Recommendation Report for Planning Permission

REF NO:	AB/48/19/PL
LOCATION:	Sparks Yard 18 Tarrant Street Arundel BN18 9DJ
PROPOSAL:	Change of uses to form an upper floors single, four bedroomed residential unit (use class C3a) & a ground floor commercial unit (use classes A1, A2 and B1a), together with all associated works. This application affects the character & appearance of the Arundel Conservation Area.

A6001-07

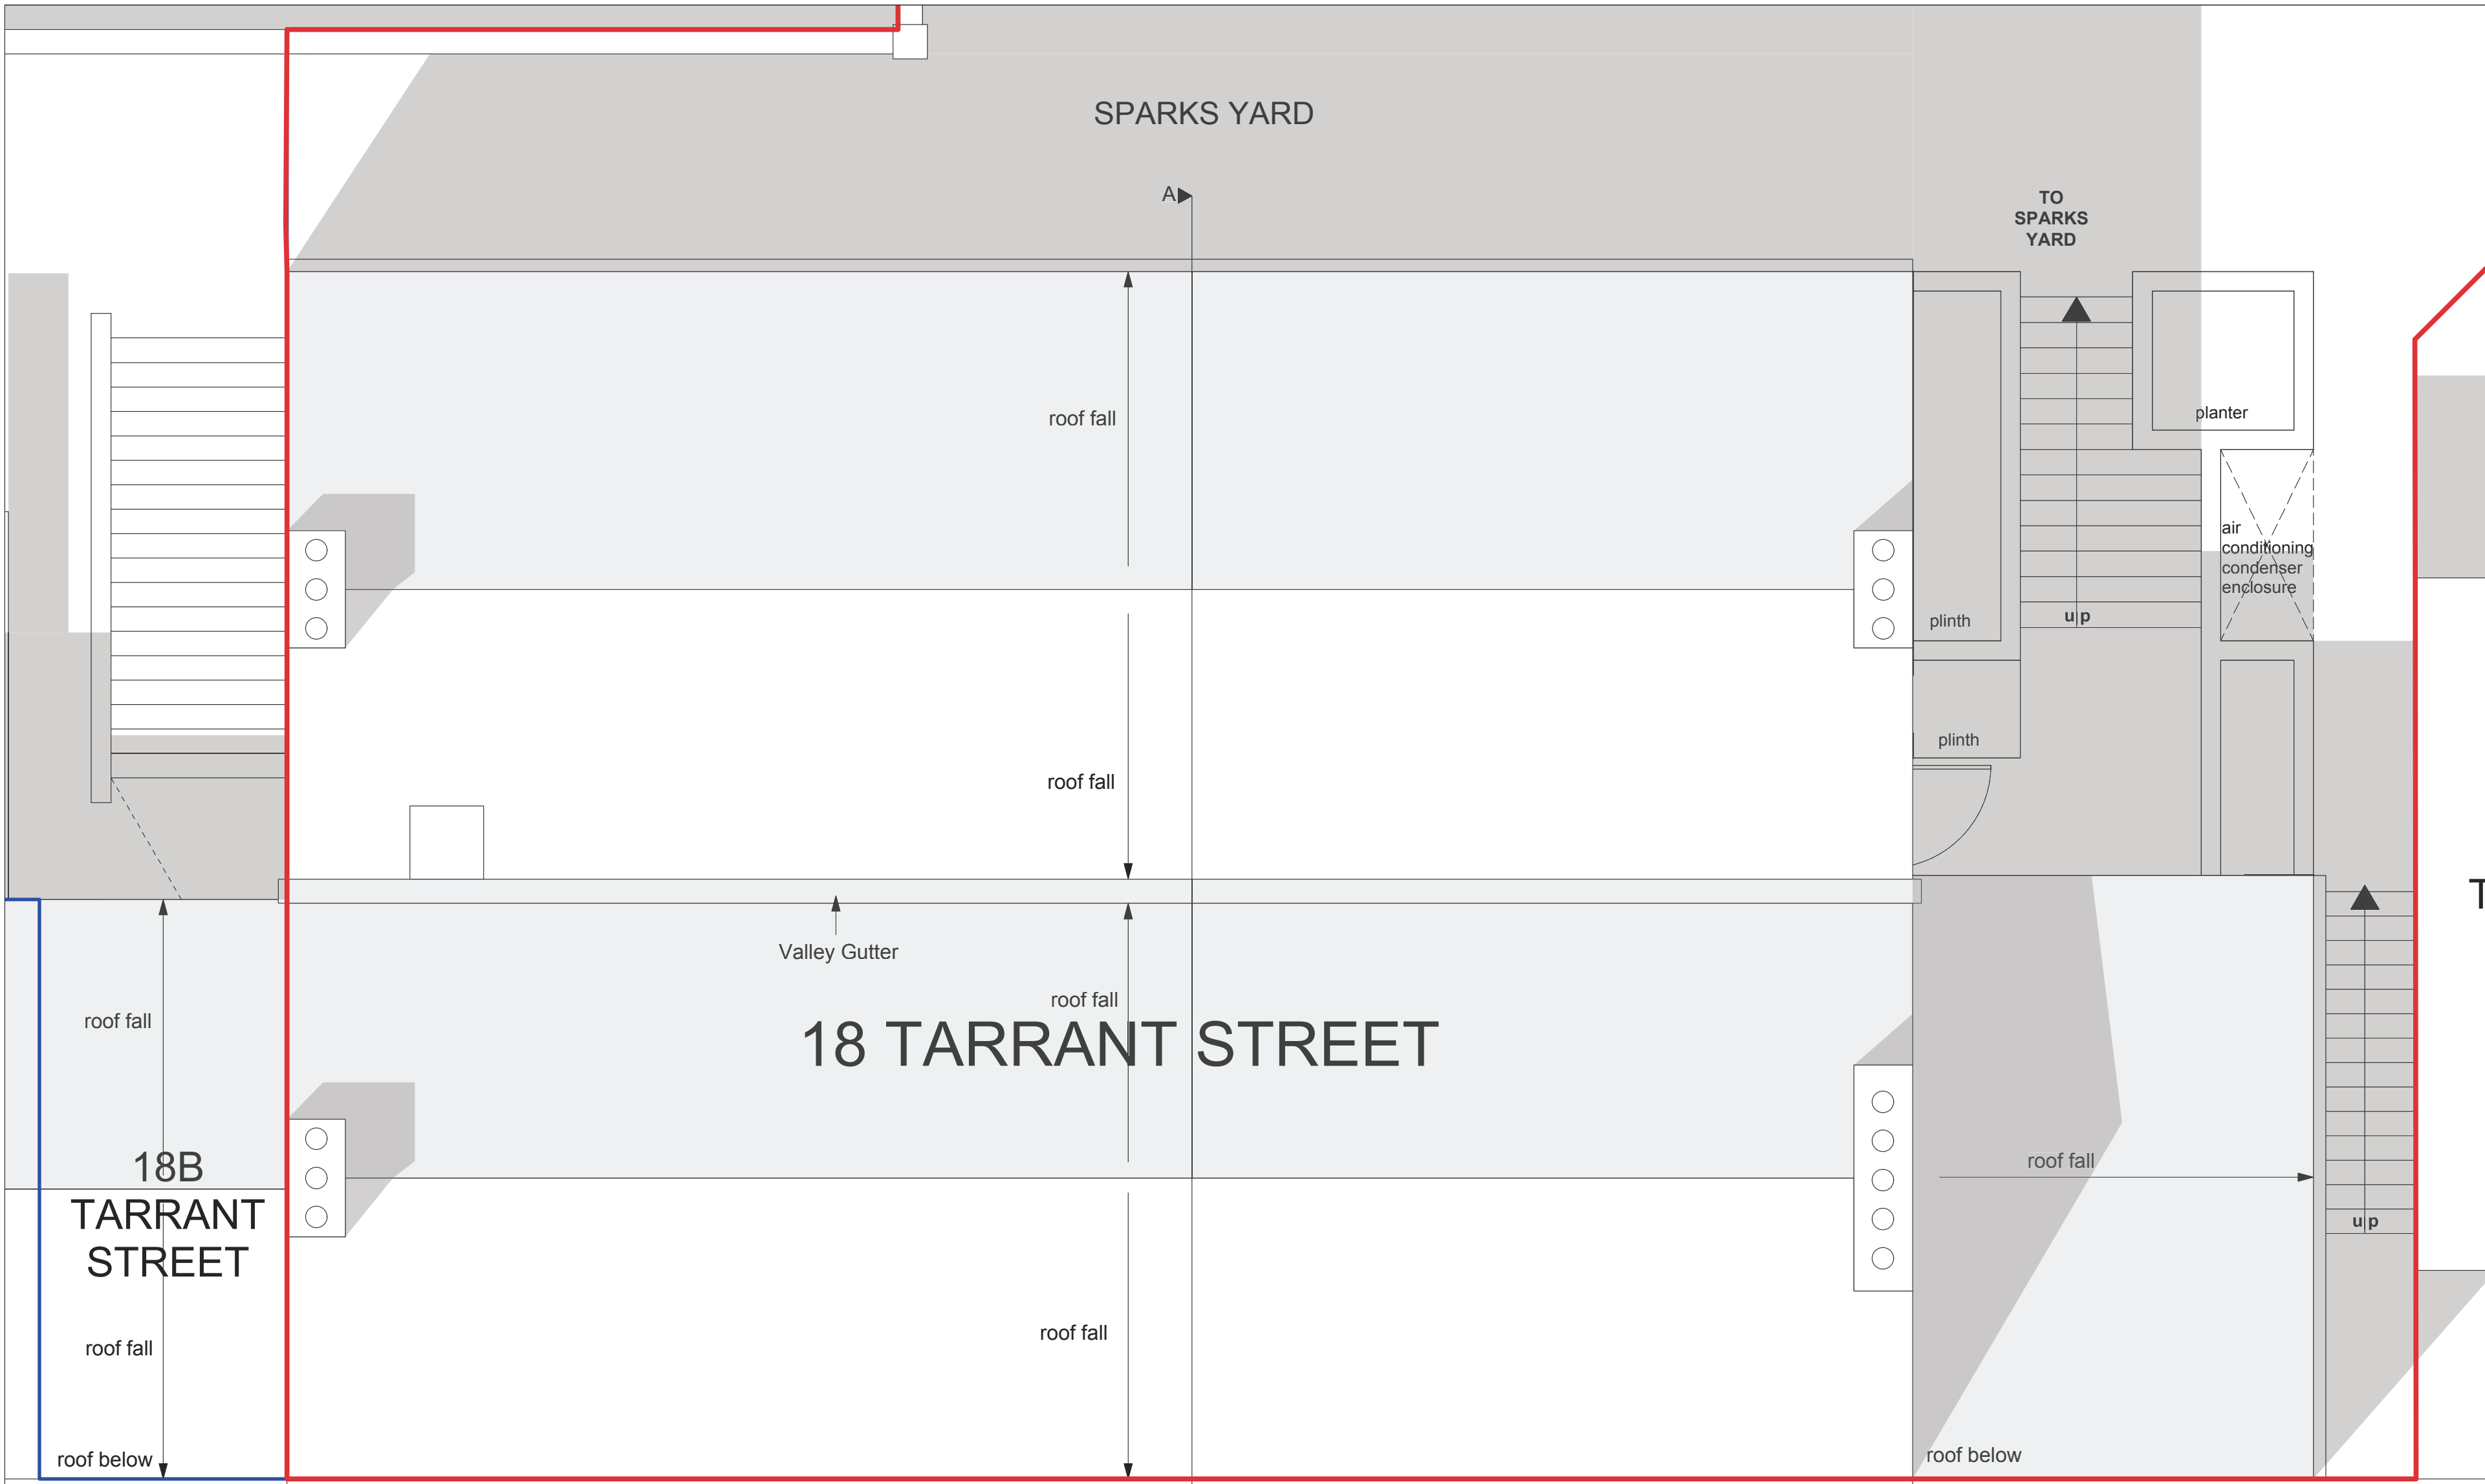
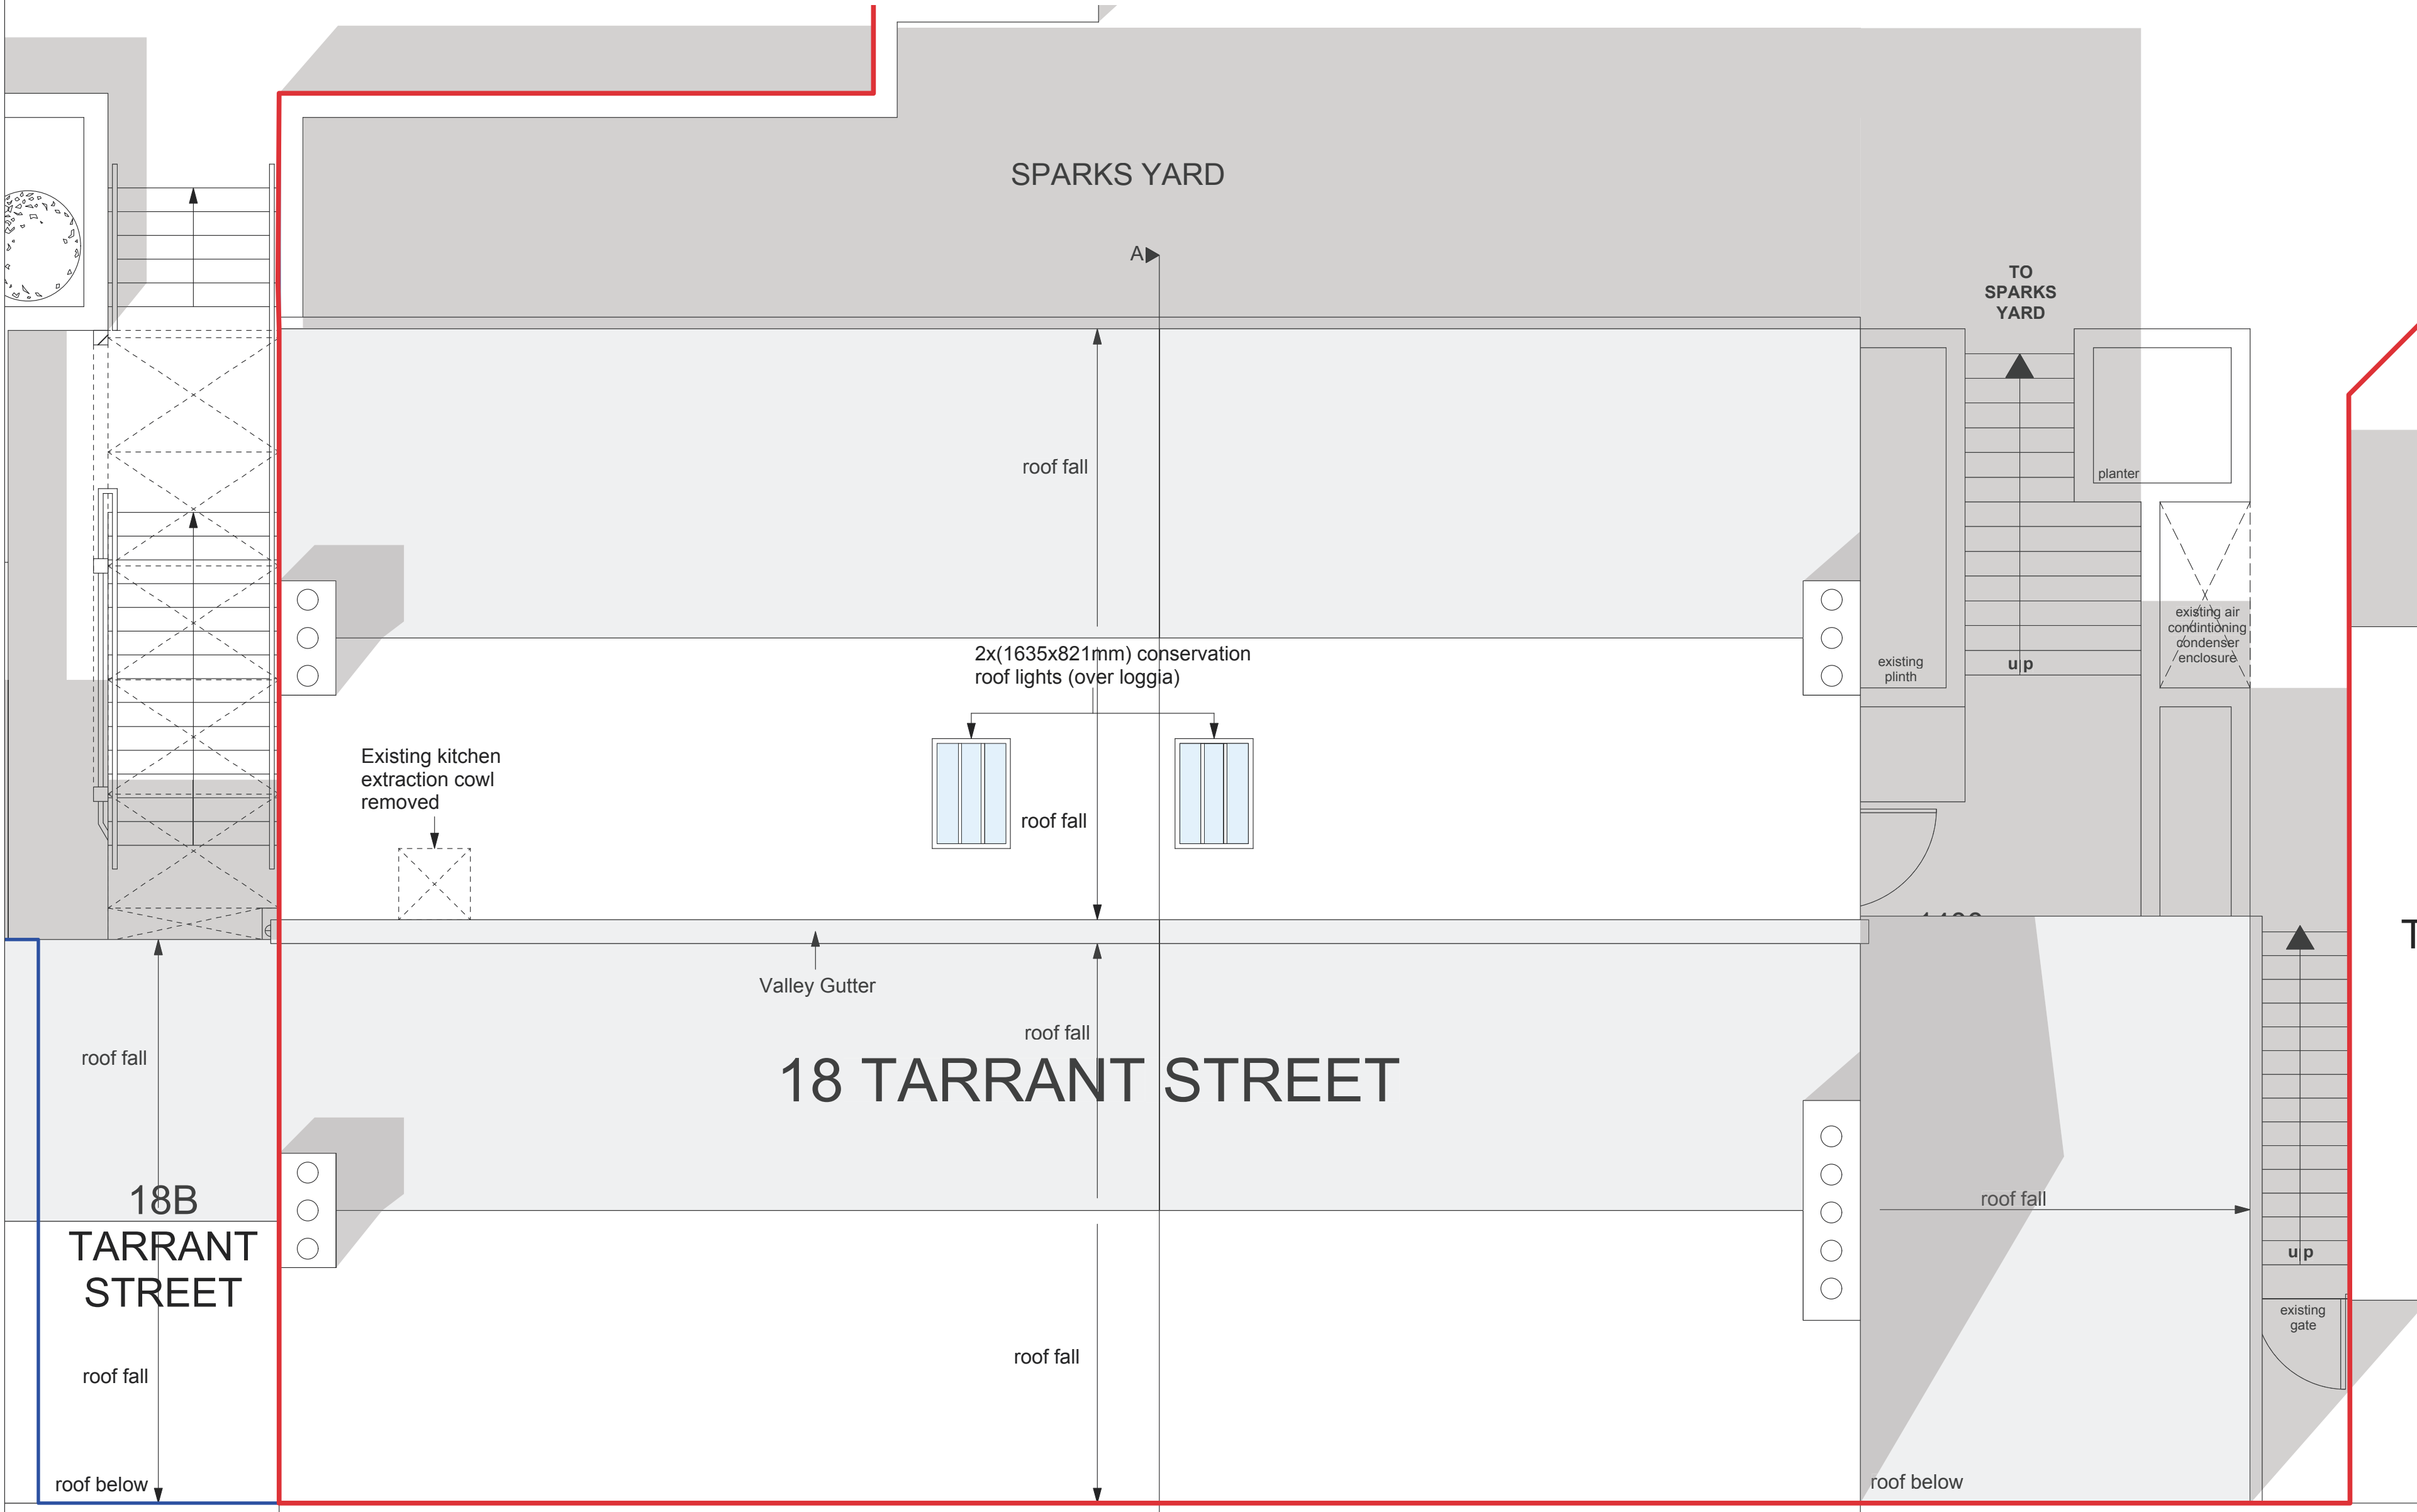
The application proposes that 3 existing windows and 1 external personnel access are closed and infilled with brickwork to match that surrounding the existing openings. It is also proposed to remove all redundant drainage pipework from this elevation and to add 2no. conservation roof lights in the central 'roof valley' of the building. These south wing roof lights are visually concealed from all surrounding parts of the town. The existing Kitchen extract flue at the western end of this valley will be removed.

A6001-03A

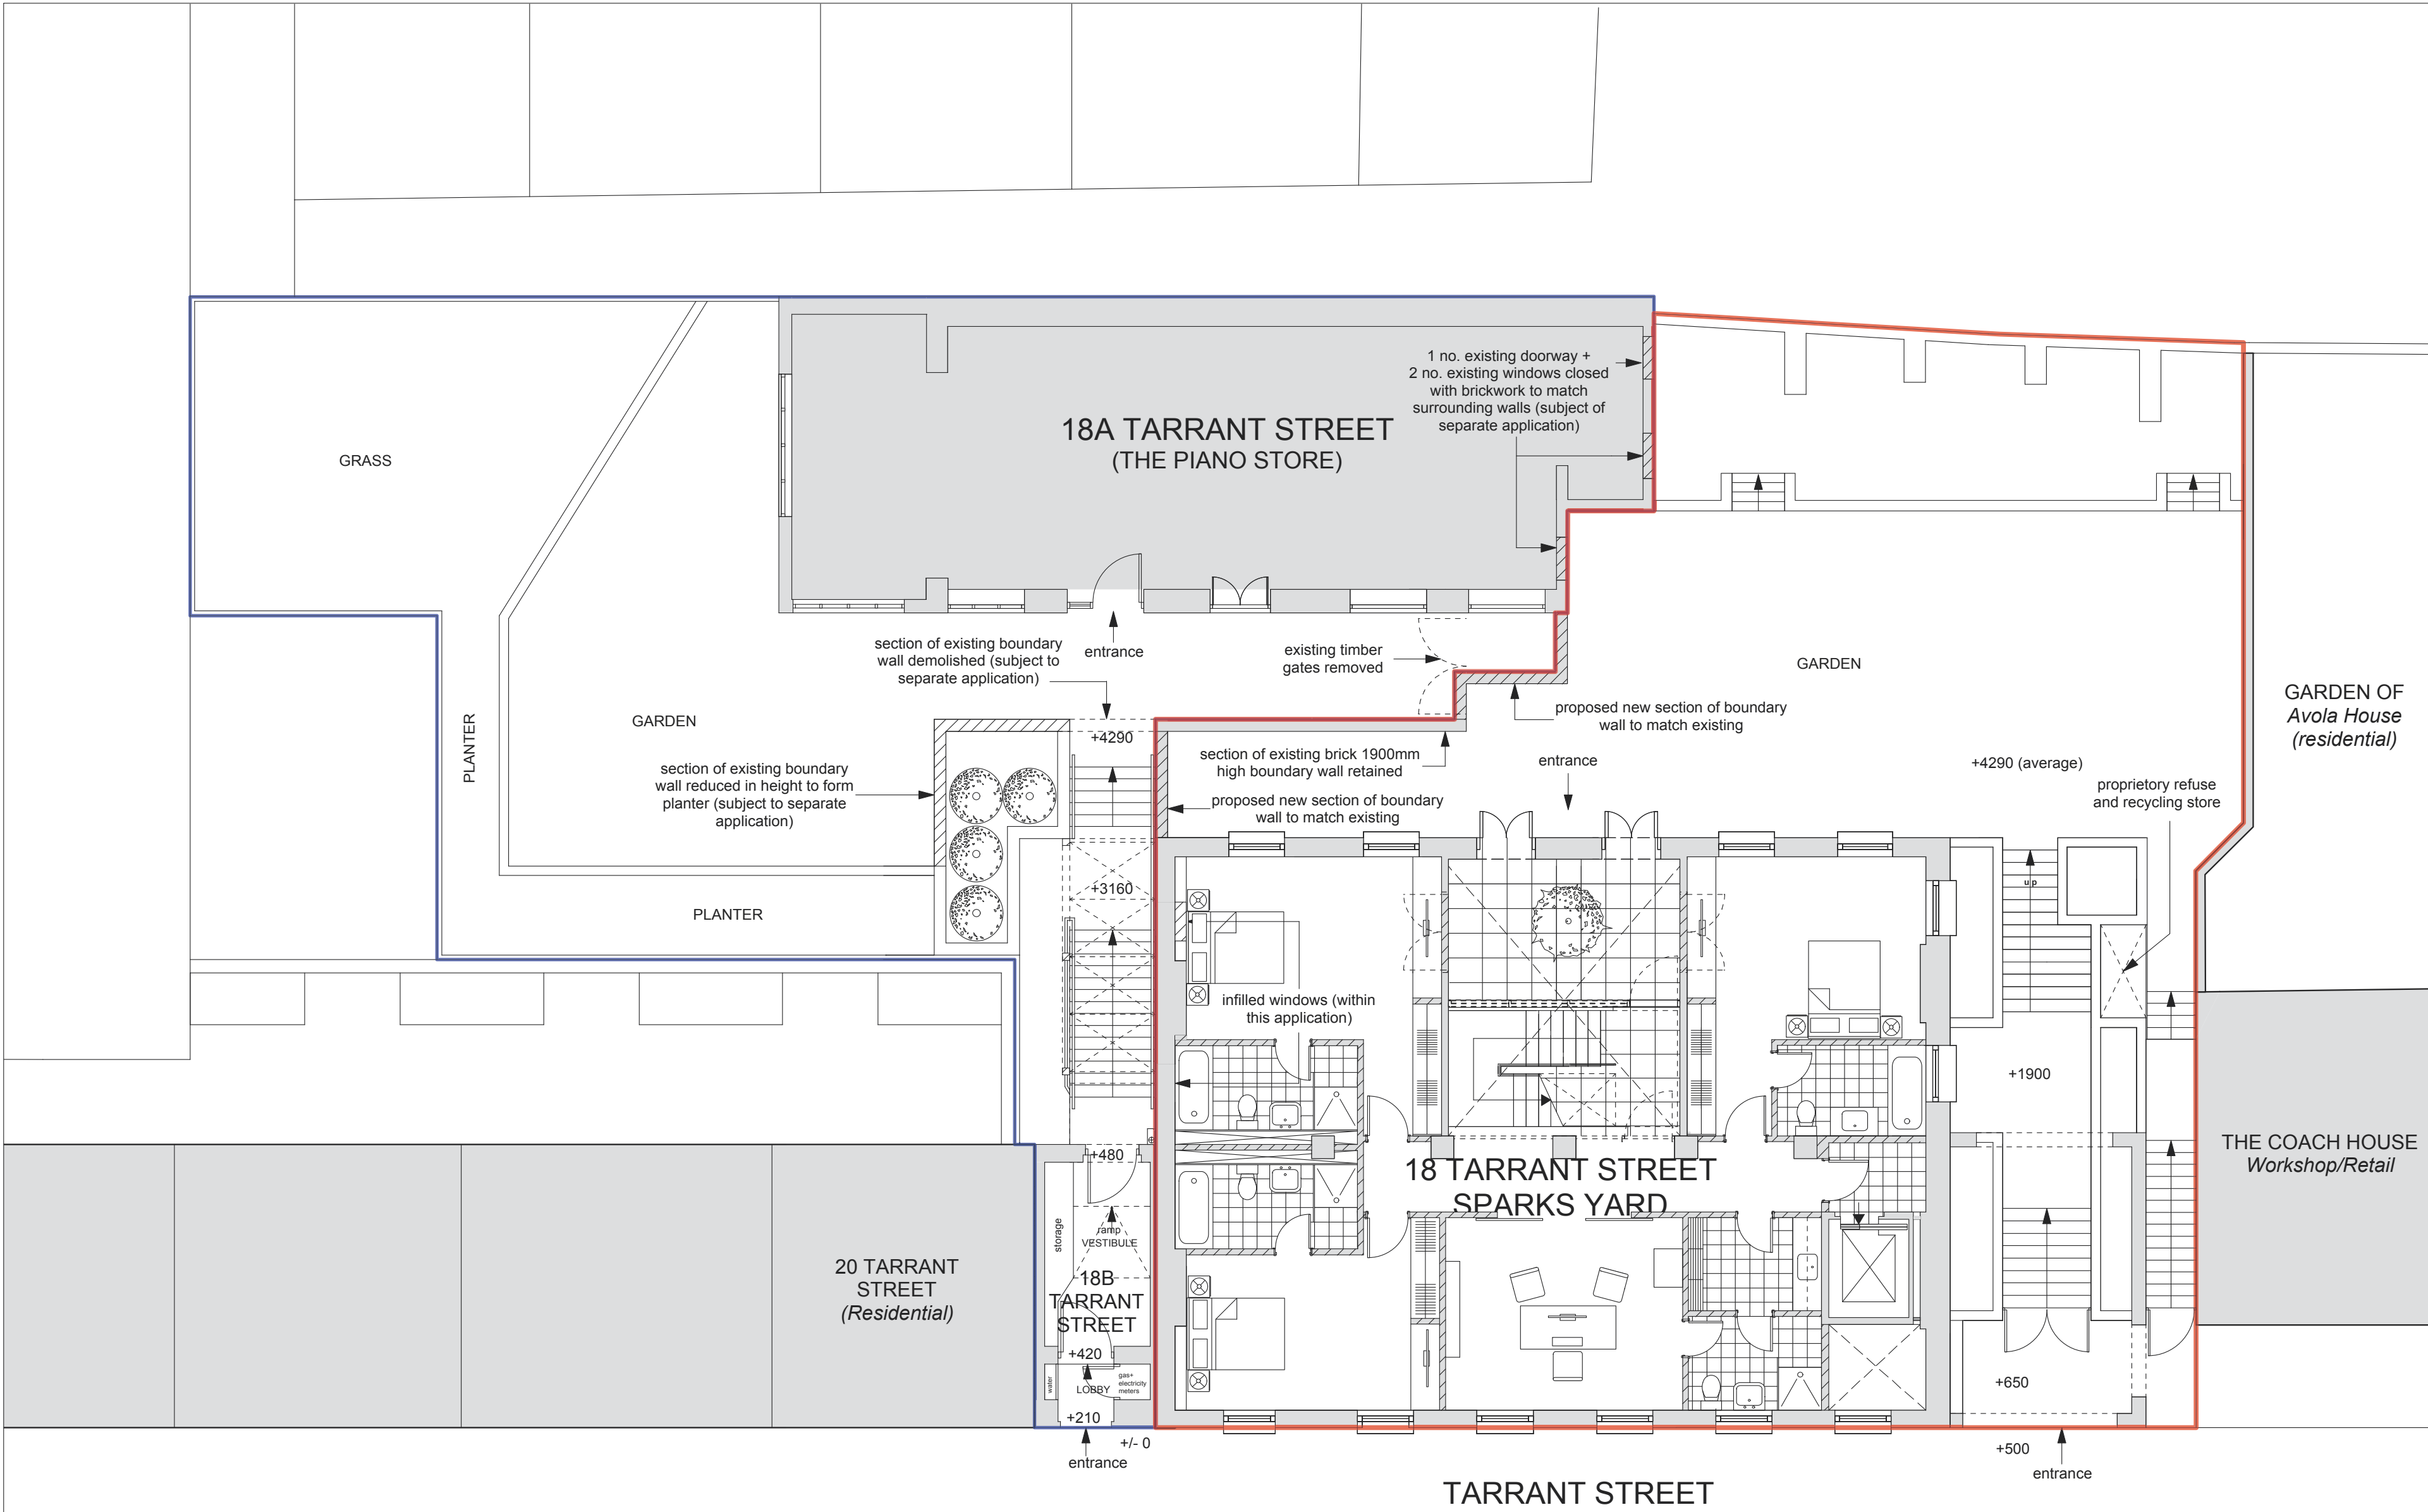
- The alterations to the middle floor allow for modern day living, whilst creating a spacious layout.
- Covering internal brick walling with plasterboard should be reconsidered.
- More information should be submitted relating to the works to the curtilage wall.
- The removal of all damaging drainage pipework from the western elevation will have a positive impact upon the appearance of the building.

Works to the boundary wall have subsequently been satisfactorily clarified.
